PROJECT NO. PR-2021-005628

Application No. SD-2021-00214

**Re: Summary of Modifications to address DRB Comments
Preliminary Replat of Tract 17, Bulk Land Plat of Artiste
PR-2021-005628/SD-2021-00214**

PR-2021-005628/SD-2021-00224 DRB Comments Received 1/12/22

CONCEPTUAL UTILITY PLAN			
MDS CITY CENTER			
DRAWN BY:	AO	DATE:	11/11/2021
CHECKED BY:	MJB	BHI PROJECT NO.	20220088
		SHEET NO.	1 OF 1

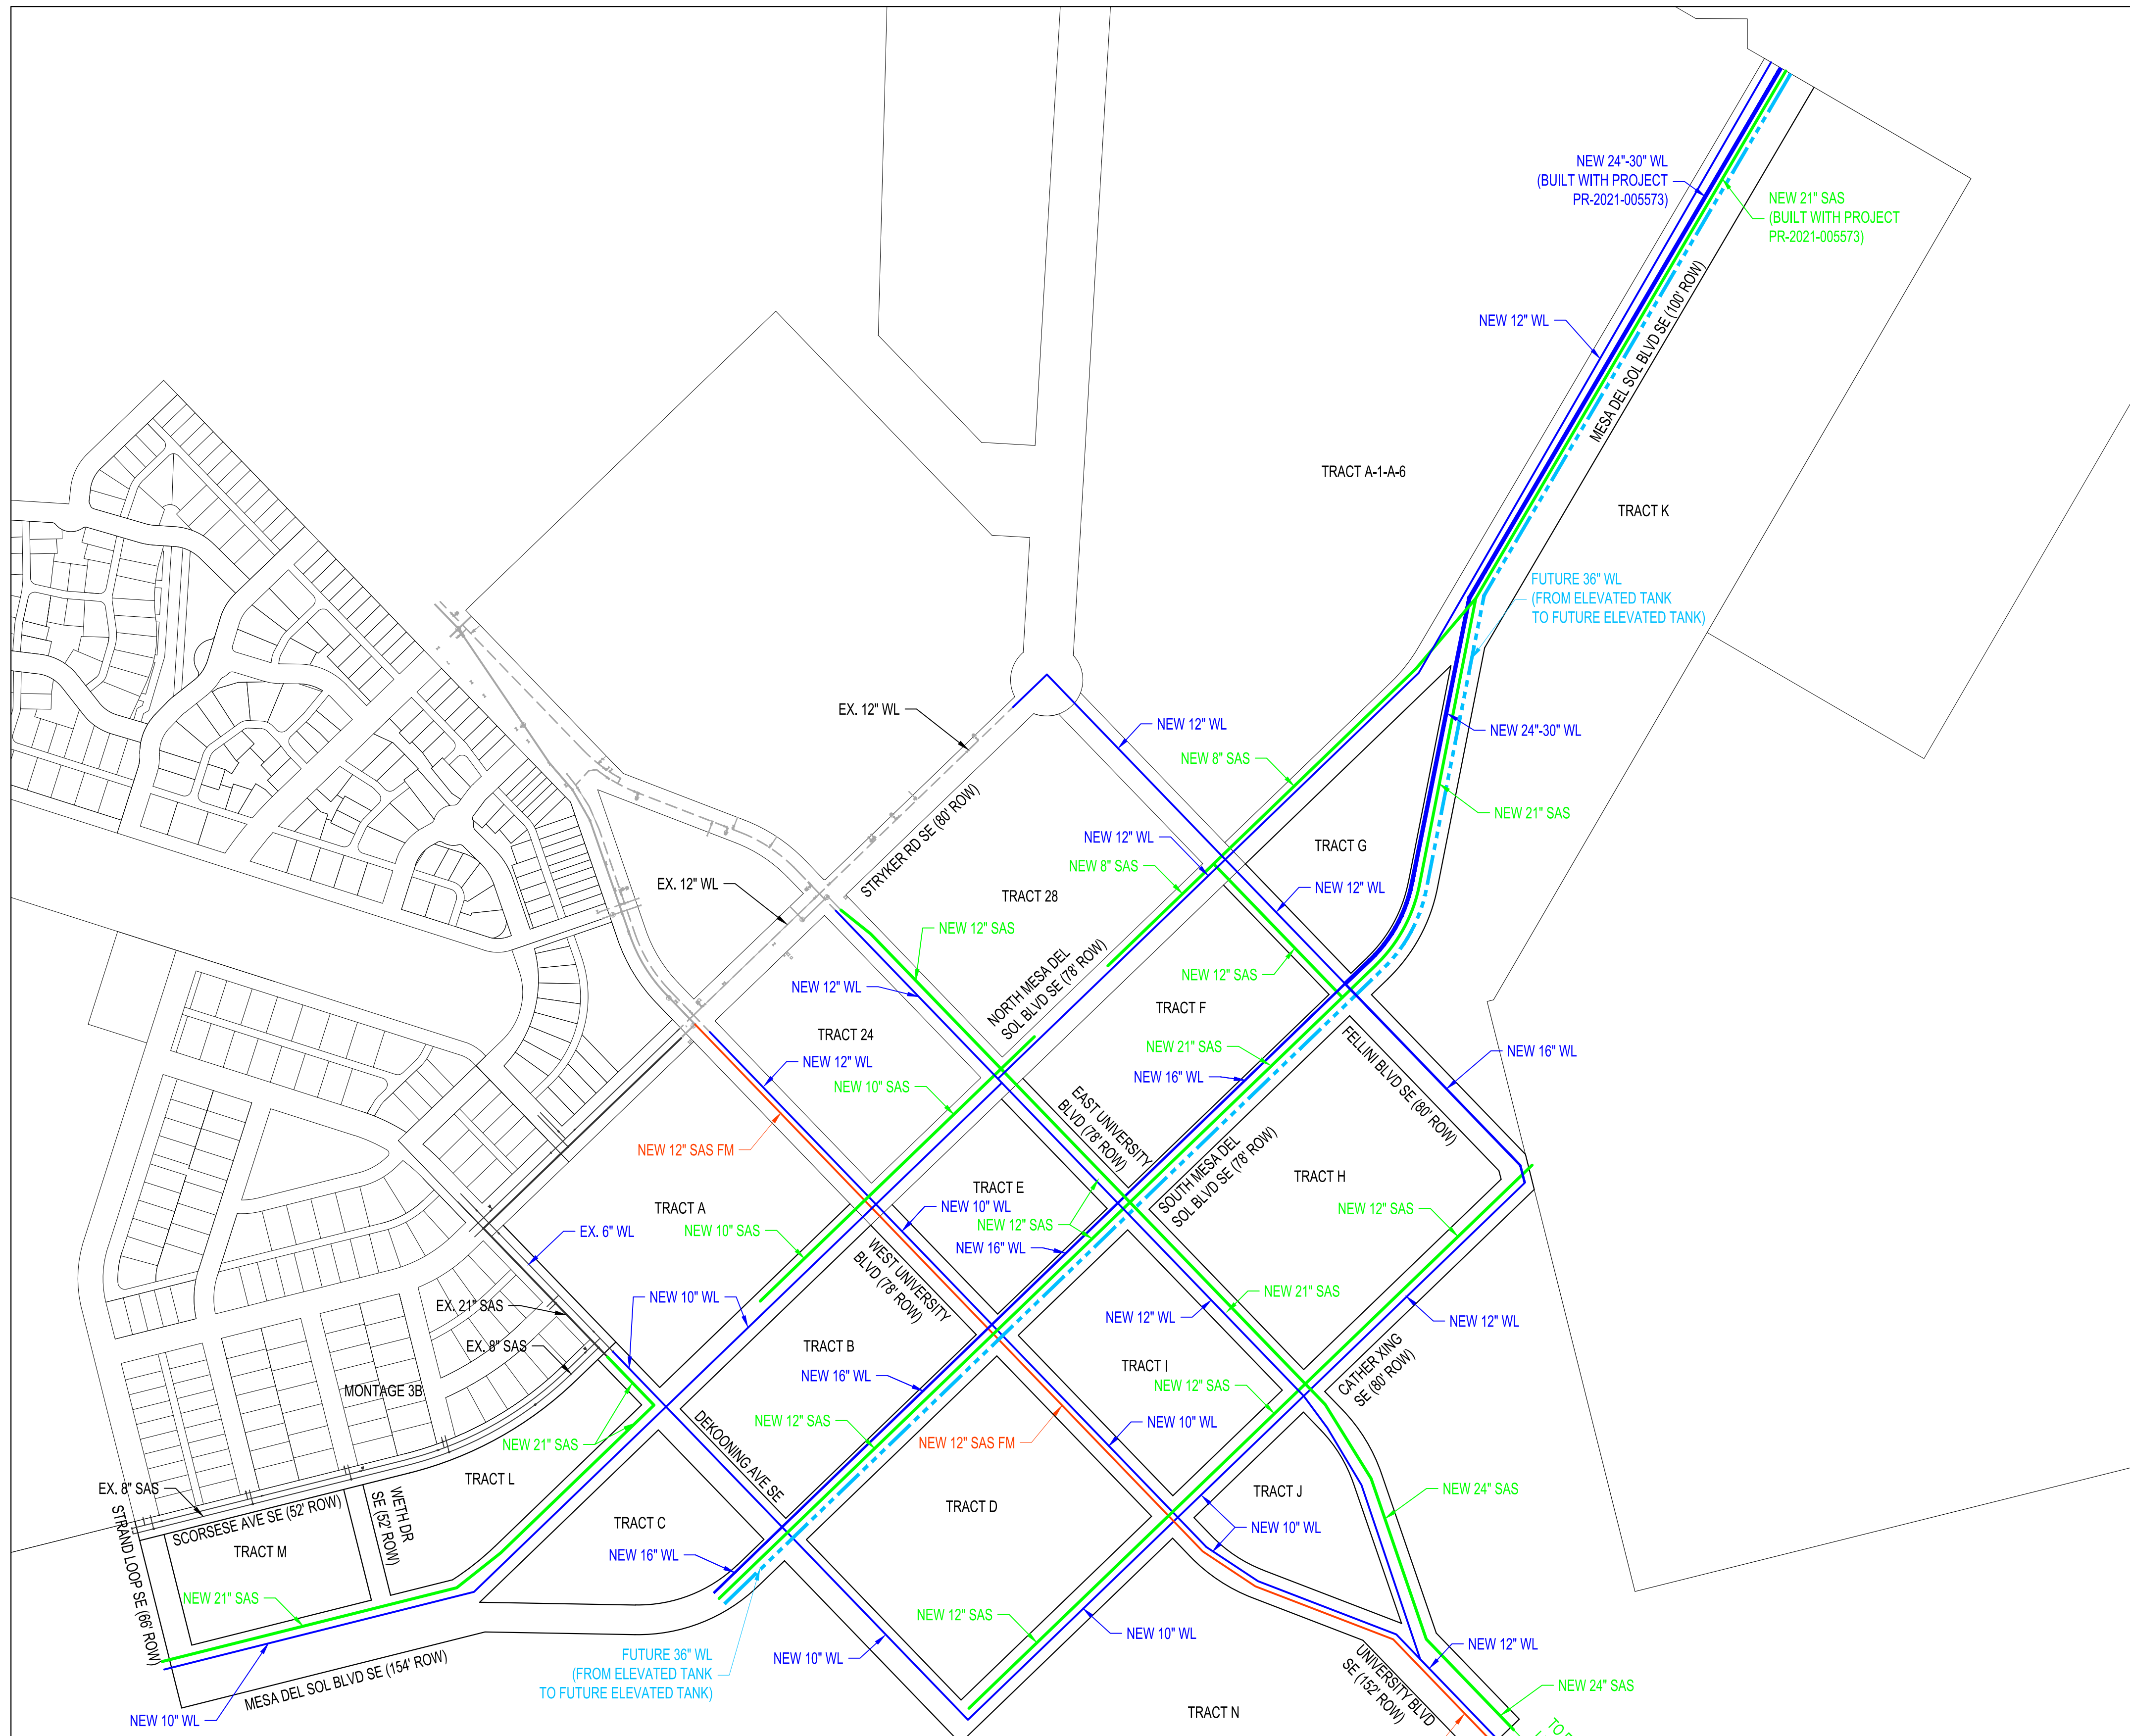
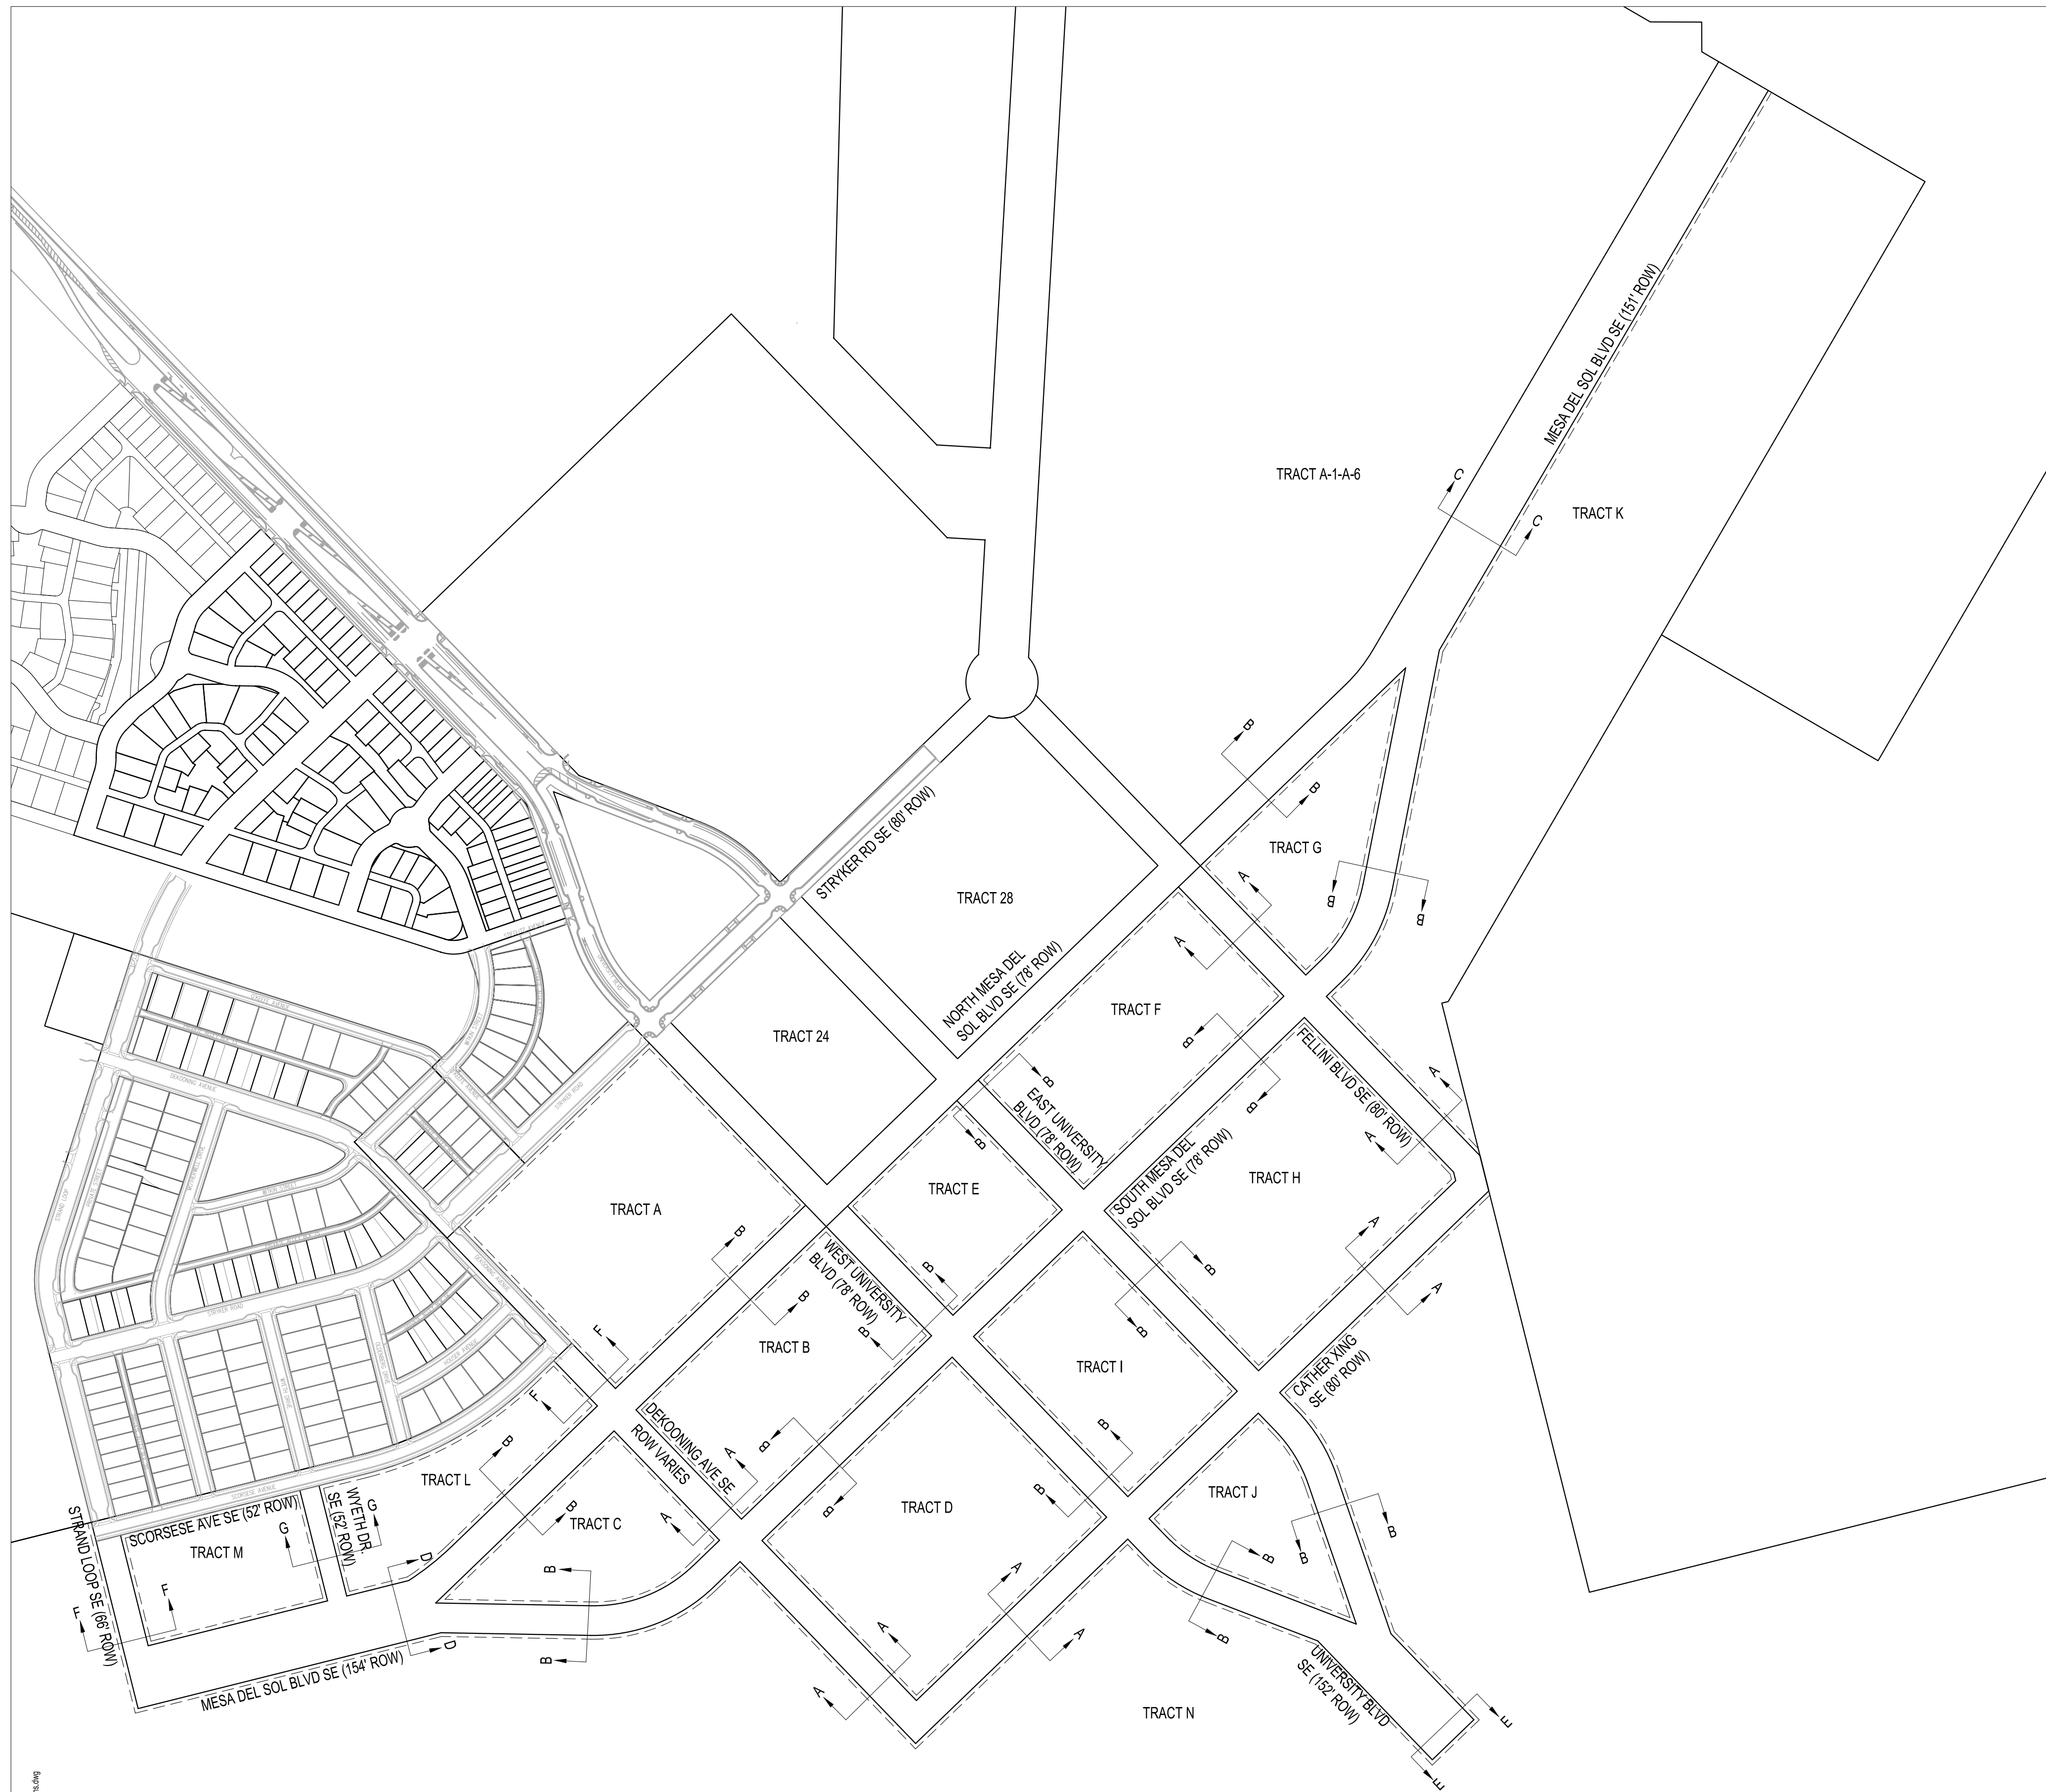
Status	Subject	Commentor	Comment	Drawing Revision Required (yes or no)	Revised sheet #	Response, if necessary
No action necessary	Preliminary Plat	ABCWUA	1. Please revise the easement callout to say “public water” and “public sewer” and to make distinct from “utilities”.			This comment was specific to the Bulk Land Plat and not necessary for this action.
	Preliminary Plat	ABCWUA	2. The agenda item summary includes dedication of right-of-way for MDS town center. Please confirm this portion of the project is not applicable to the current bulk plat.			The granting of MDS Blvd is applicable to this Preliminary Plat.
	Preliminary Plat	ABCWUA	4c. Future Subdivision Infrastructure Lists:			The design team is still working with ABCWUA regarding comments. Extents have been updated to reflect the current site plan as well as the existing/proposed conditions of this line.
	Preliminary Plat	ABCWUA	i. Please provide a utility plan to assist in the review of the infrastructure list. This shall include water, sanitary sewer and non-potable.			A conceptual Utility plan has been provided with this submittal.

Preliminary Plat: Infrastructure List	ABCWUA	v. A sewer pump station is also required for this area to gain service. The applicant shall provide the anticipated flow from this development area compared with the total anticipated build-out flows to the pump station. This information is necessary to size the force main coming from the pump station. 1. The lift station and force main need to be included in the infrastructure list.			The forcemain and lift station have been included. The current forcemain size is noted as 12” maximum and anticipated to be confirmed during design.
	Preliminary Plat: Infrastructure List	ABCWUA	vi. The non-potable line is currently required to be a 16-inch diameter main. This is based upon a draft non-potable master plan for Mesa del Sol. A final version of this report is required to confirm the non-potable main sizing.			a non-potable line has been added to the miscellaneous improvements section.

Preliminary Plat: Infrastructure List	ABCWUA	vii. Justification of the proposed water distribution main sizing will be required including an estimation of the required fire flow demands. This information is required to confirm if the proposed mains are sufficiently sized for anticipated users.
